CITY OF ALBUQUERQUE

March 19, 2018

**RE: Nusenda Credit Union Admin Expansion
4100 Pan-American Freeway NE
Grading and Drainage Plan
Engineer's Stamp Date 3/15/18
Hydrology File: G16D154**

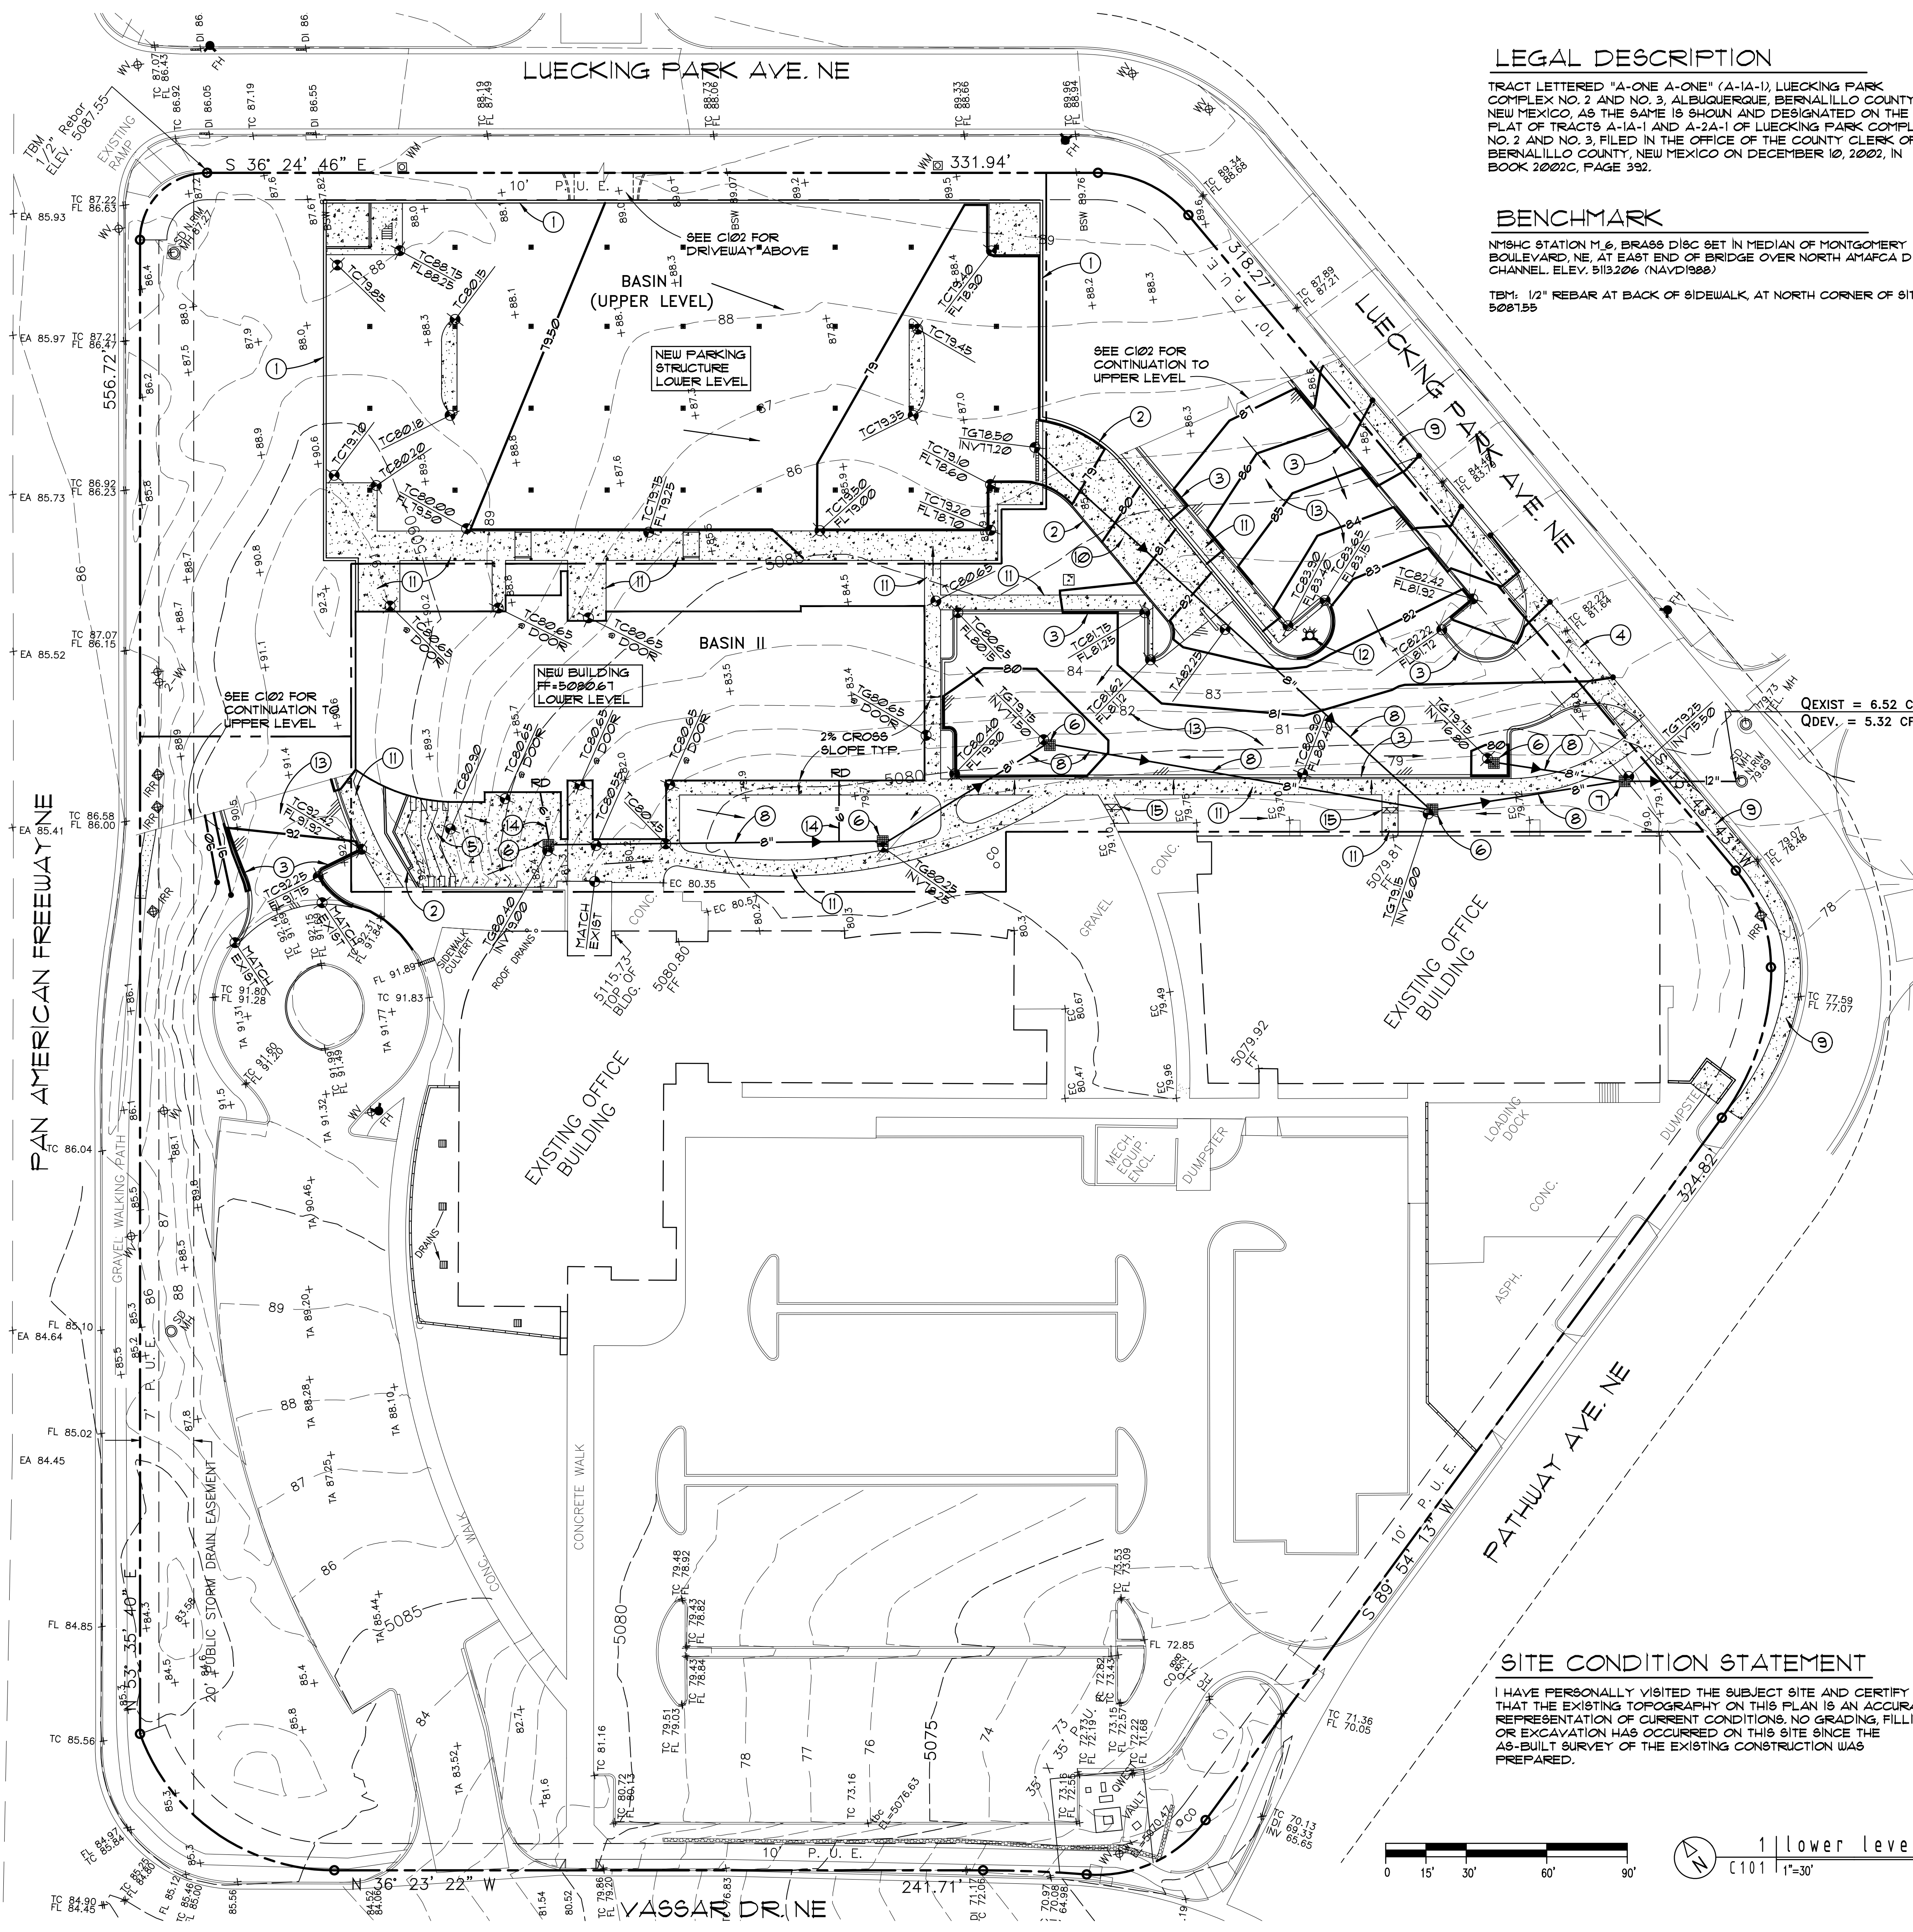
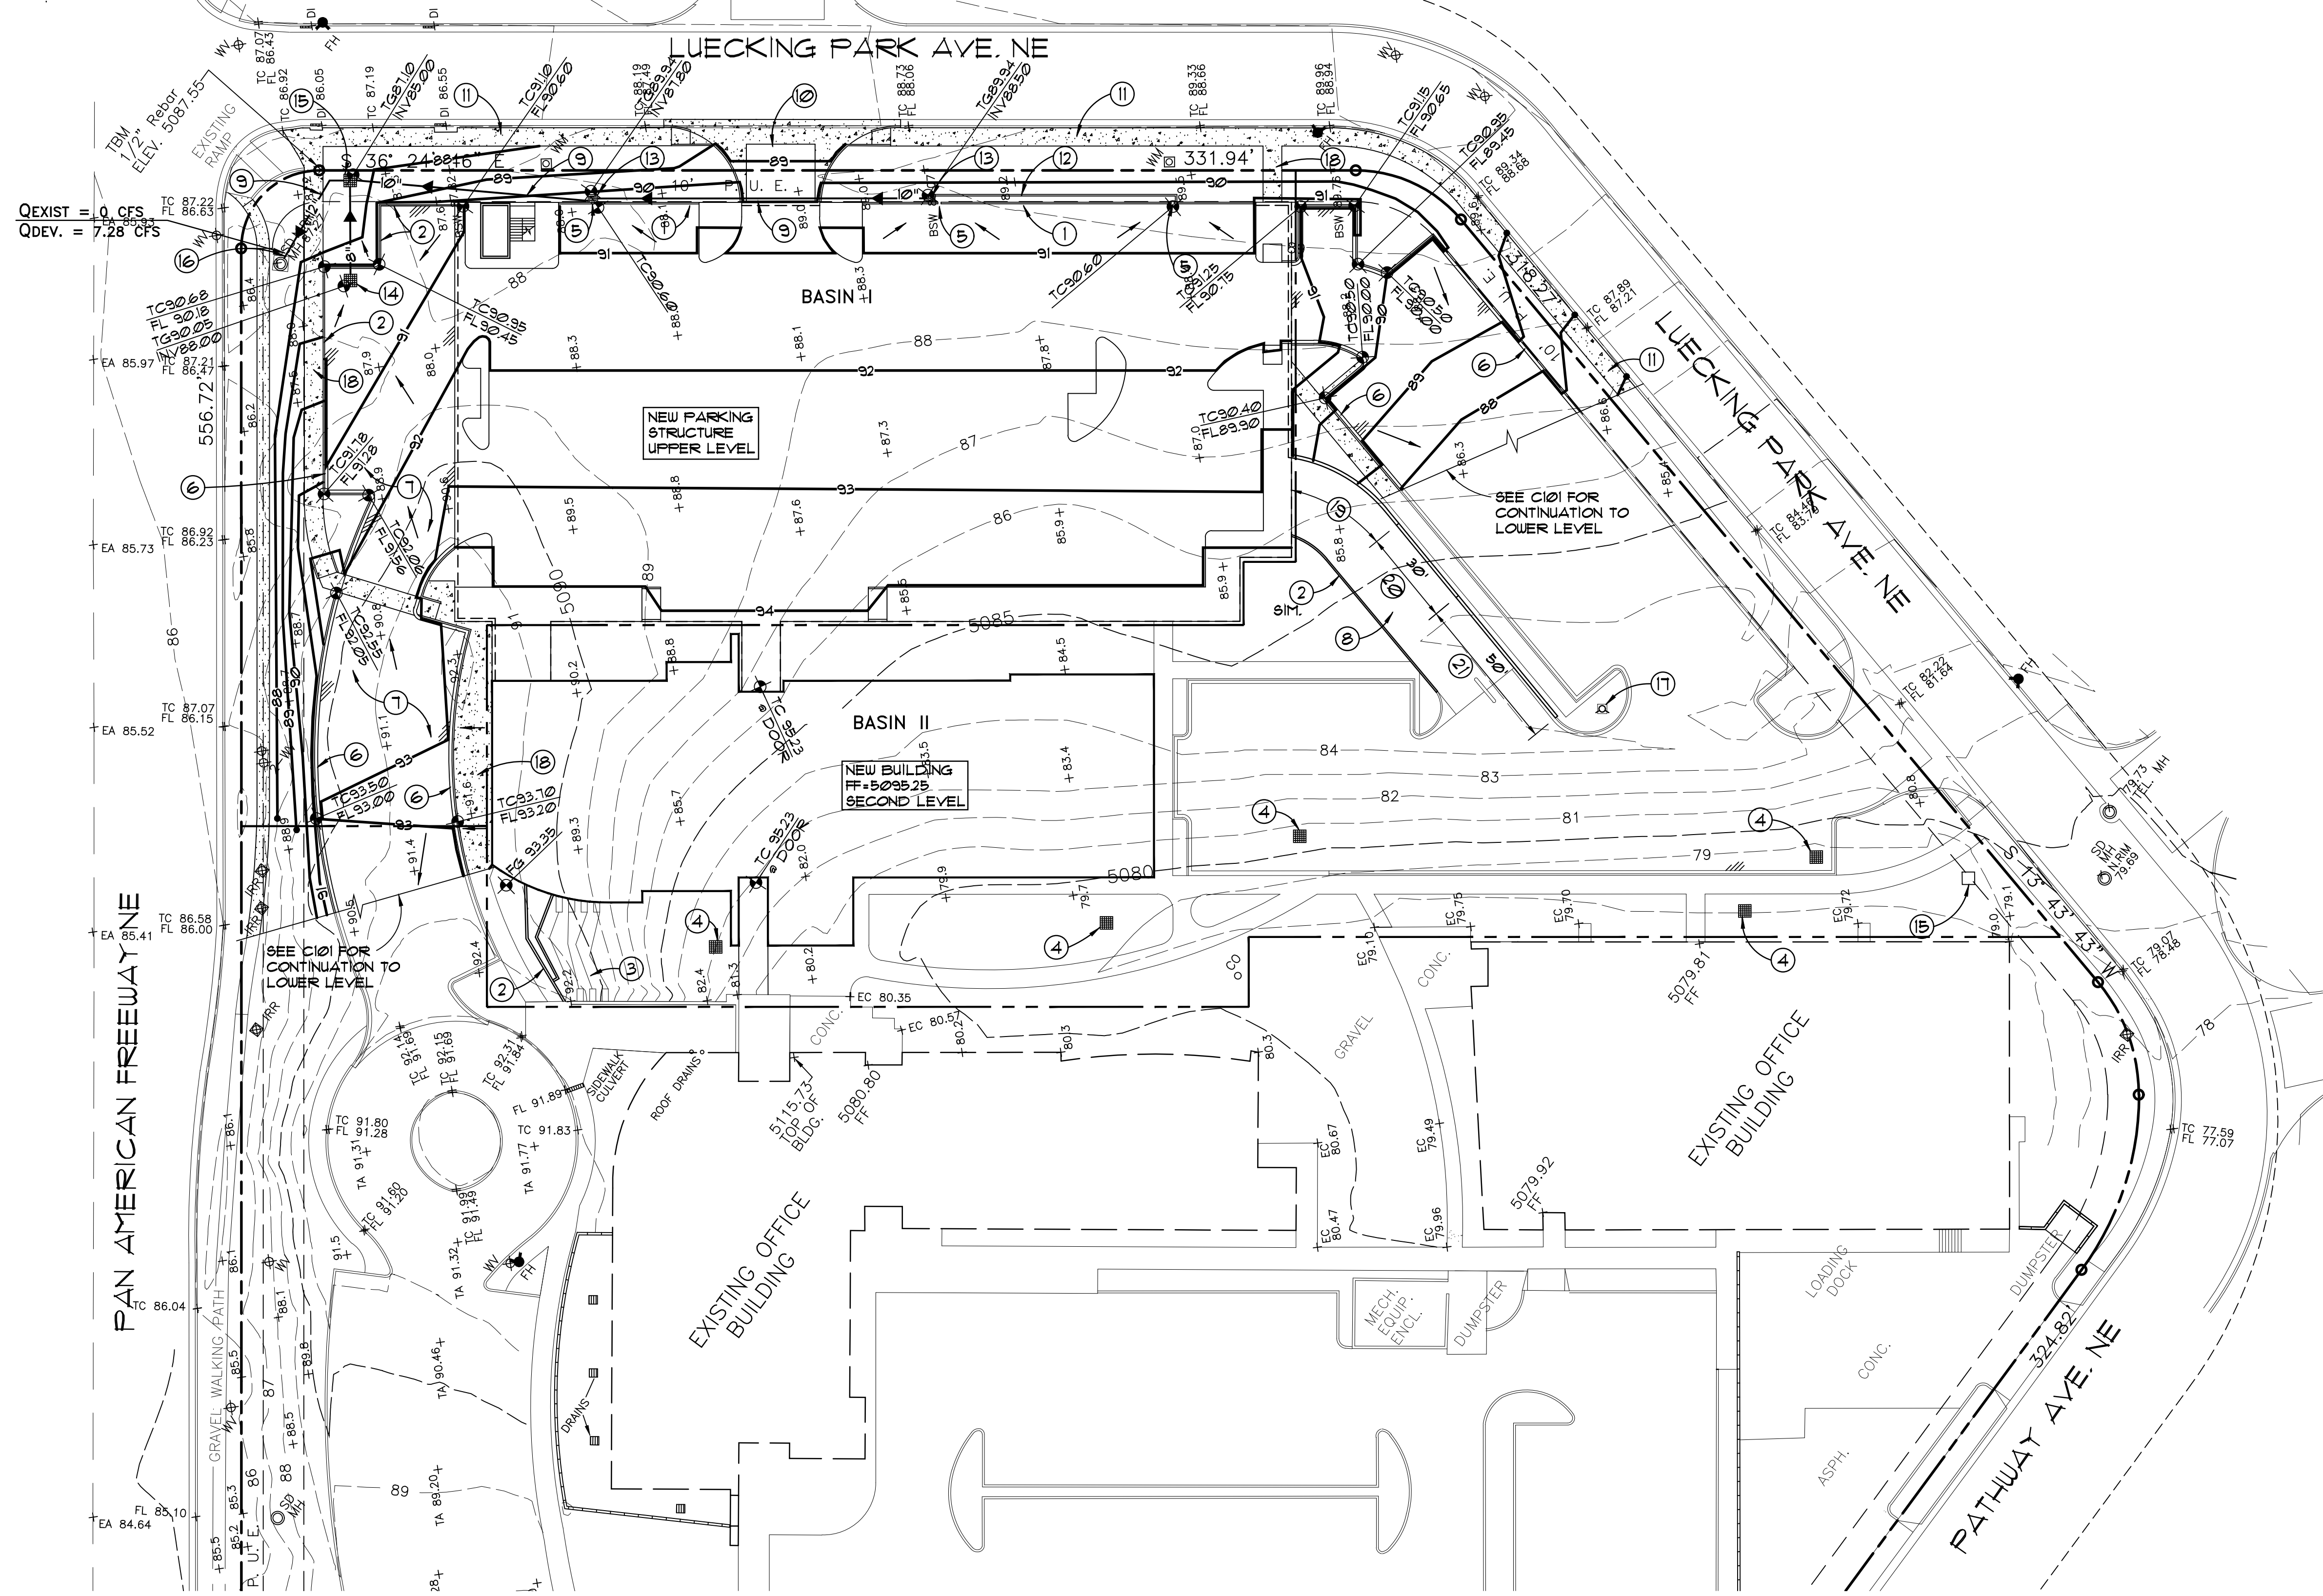
1. Please recheck your first flush calculations. I calculated a new imperious area of only 2.436Ac and first flush runoff volume of 3007CF, based on your proposed basin conditions. This results in a lower payment of Fee-In-Lieu.
2. This project will require a public Work Order for the work along Luecking. Add a note to this Grading Plan that "No work is permitted in the Public Right-of Way without an approved Work Order" or similar.
3. This project requires an ESC Plan, submitted to the Stormwater Quality Engineer (Curtis Cherne PE, ccherne@cabq.gov or 924-3420).
